Our Ref: FE385 / KEH / AGE

18<sup>th</sup> February 2026

## **PROVIDENCE STREET, EARLSHEATON (PLANNING REF: 2024/60/92779/E) – RESPONSE TO ECOLOGY COMMENTS DATED 30<sup>TH</sup> JUNE 2025**

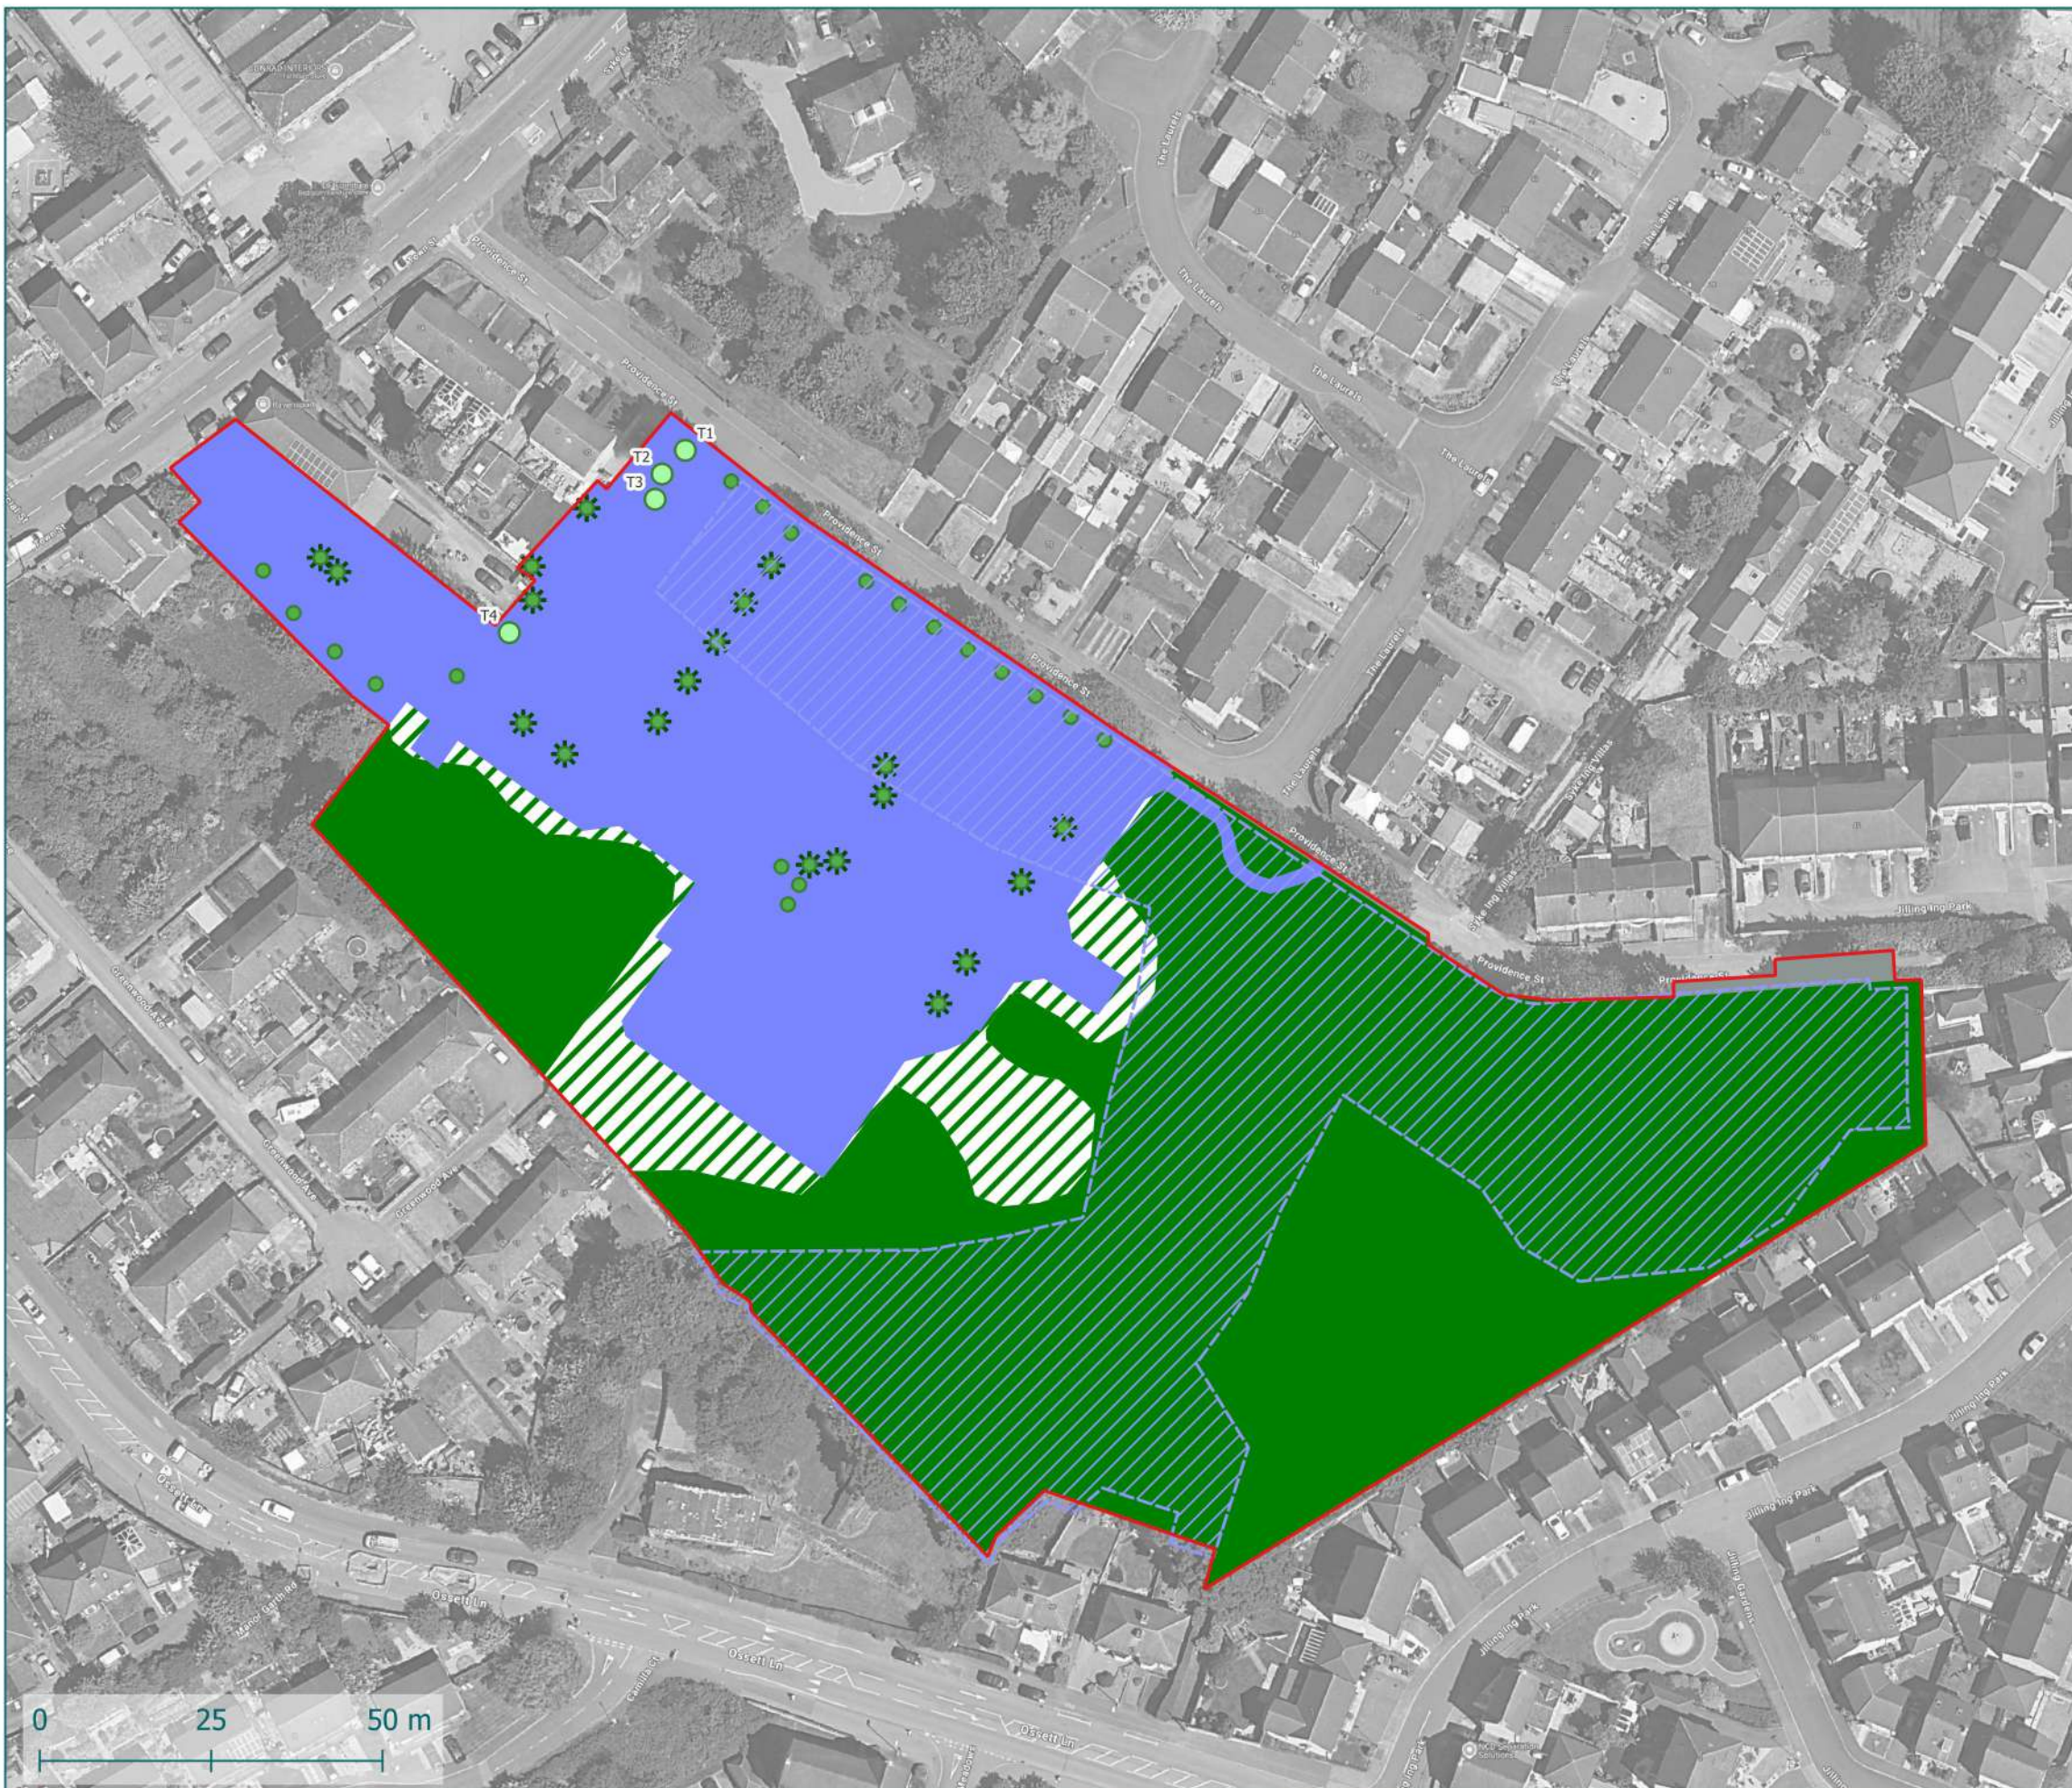
*"Even without the data concerning degradation, it is predicted that >14 biodiversity units is to be lost due to this development, which is a lot with no plan to make up any loss / shortfall. There is not clear plan set out in a Biodiversity gain Plan and the Statutory metric of how Schedule 7A of the Town and Country Planning Act 1990 (as inserted by Schedule 14 of the Environment Act 2 2021) is to be achieved. A report and metric showing this plan must be provided before further commentary is made."*

Given the outline nature of the proposals no post-development calculations had been completed previously. However, this has now been run based on the Parameters Plan<sup>4</sup> and Illustrative Masterplan<sup>5</sup> created by JRP Associates. This has been reported in the Biodiversity Impact Assessment (Futures Ecology Ltd., FE385/BIA01, September 2025), with a brief summary provided below.

The Development Area has been assumed as a 70:30 split between Urban: Developed land; sealed surface and Urban: Vegetated gardens. This accounts for the proposed houses / roads / built development and the private gardens, road verges and Public Open Space (POS) amenity grassland. The retained onsite woodland will be enhanced and the areas without woodland cover will be restocked with trees to help compensate for previous woodland losses.

With the habitat provision and long-term management as described above, the scheme would result in a **3.54 Biodiversity Habitat Unit deficit**, which would need to be secured through offsite habitat provision / buying offsite biodiversity credits.
